# CITY OF ALBUQUERQUE

**Re: 5454 Venice Warehouse Development  
Erosion and Sediment Control Plan  
Engineer's Stamp Date 6-8-16 (B18E017)**

STORMWATER POLLUTION PREVENTION PLAN

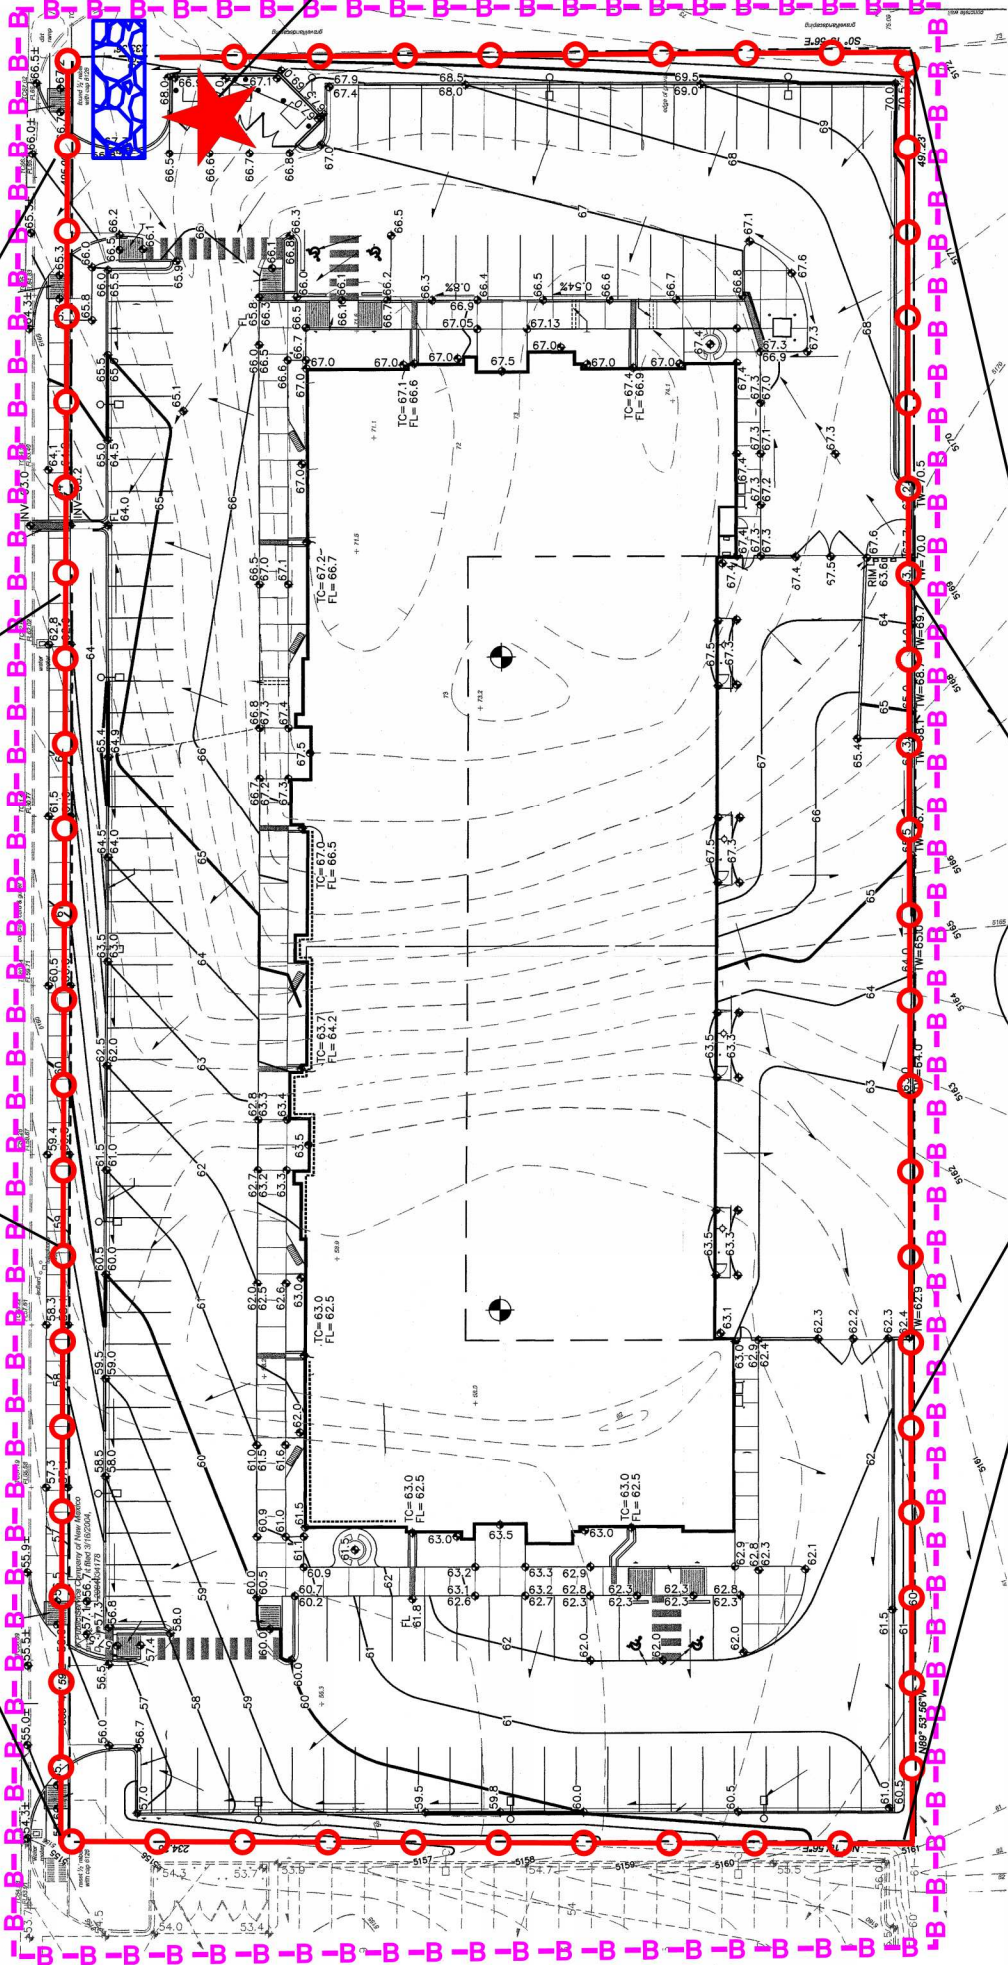
A BMP(s) is required for construction of the sidewalk culverts in Venice Blvd to prevent sediment from migrating down the street. BMP could be a mulch sock or similar or could be to not put the dirt in the street.
